Water & Sanitation District No. 1

December 23, 2019

RE: North Bay

The Woodmoor Water and Sanitation District No. 1 (the District) has received plans and documents related to the development applications referenced above. The District has the following concerns and/or recommendations:

## EASEMENT EXHIBIT

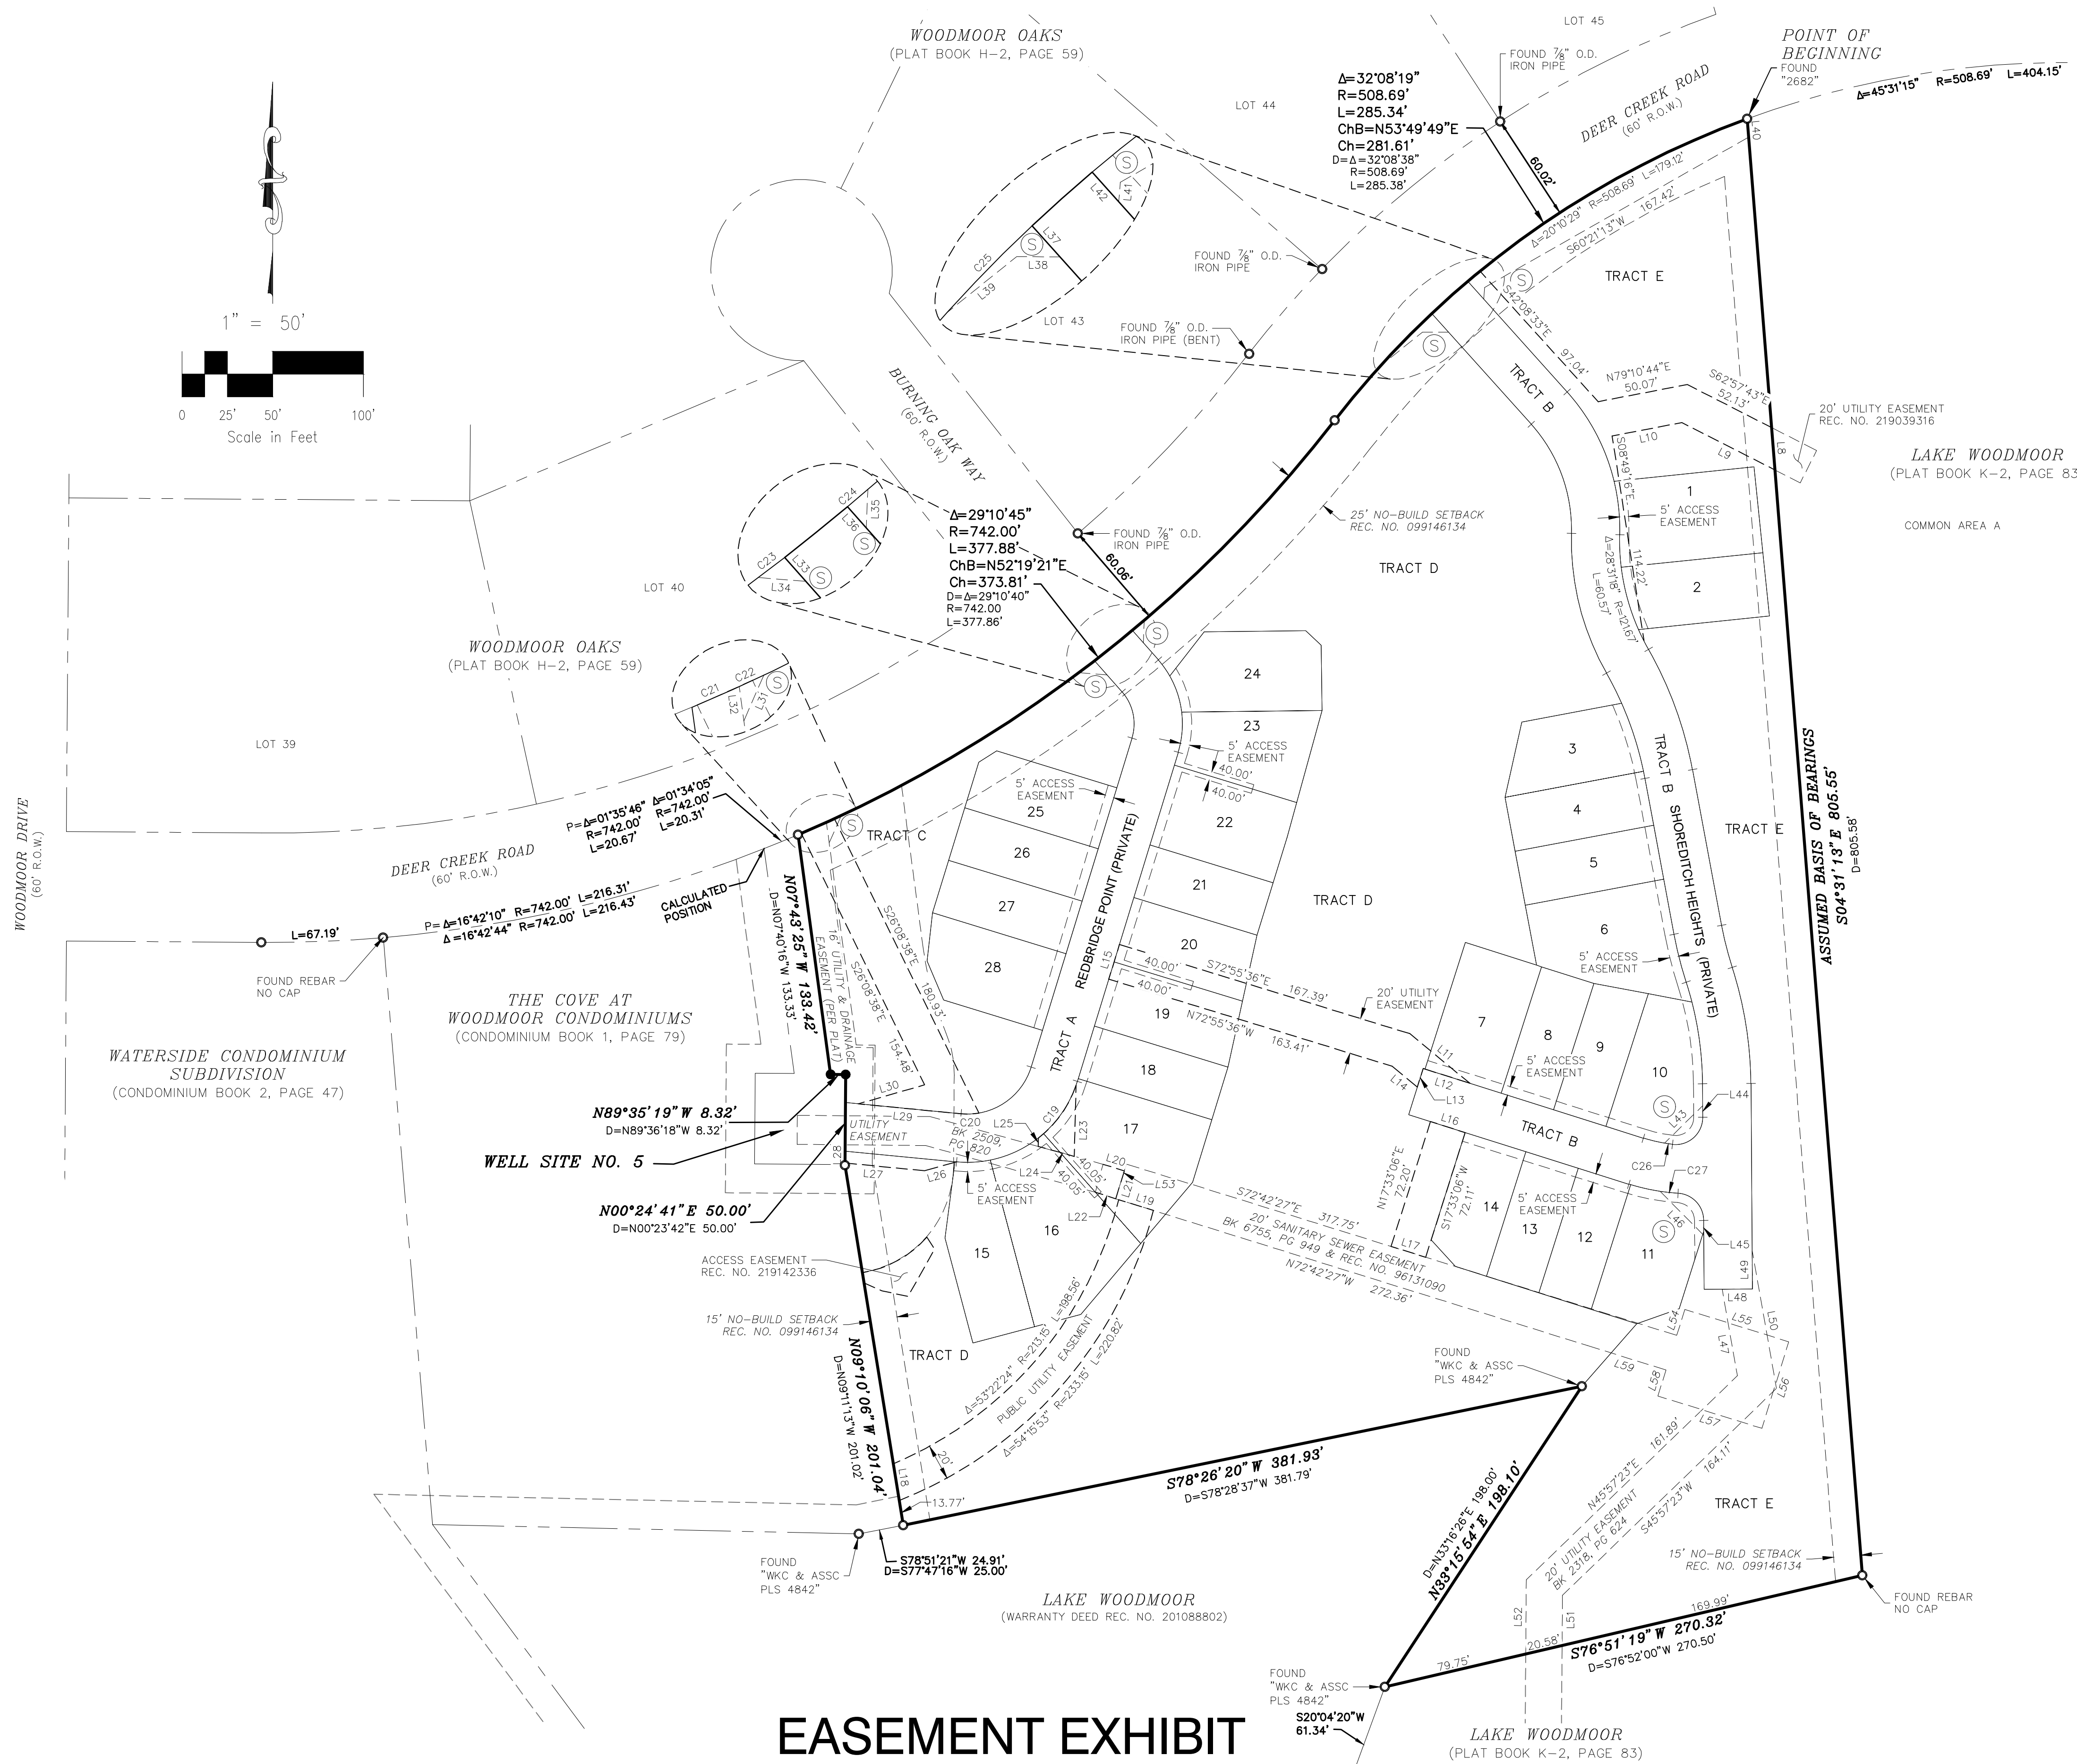
1. There are sections of utility easements which cannot be vacated because the existing utilities require 10 to 15 feet of easement on either side. Please clearly note which sections will be kept, and which sections are to be vacated.

1. There are two utility easements running across the lower center of the plat, highlighted in blue on the District's scanned plat comments. There is a gap between the two, circled in pink. Please verify that this is correct, and correct to ensure that there is no gap in utility easements.
2. Easements for sanitary sewer must extend a minimum of 15 feet on either side of the pipe. Please verify that the easement in the northeast corner of the plat is substantial, and note the width.
3. Will Tracts A, B, and C be used as utility easements? If so, please clearly note.
4. Please label the description and width, which must be 20 feet at minimum, of the easement for the raw water pipeline, beginning on the northwest corner of the plat.

5. To the west side of Lot 14, there is a dotted line. Is this indicating an easement? If so, please label and note the size.
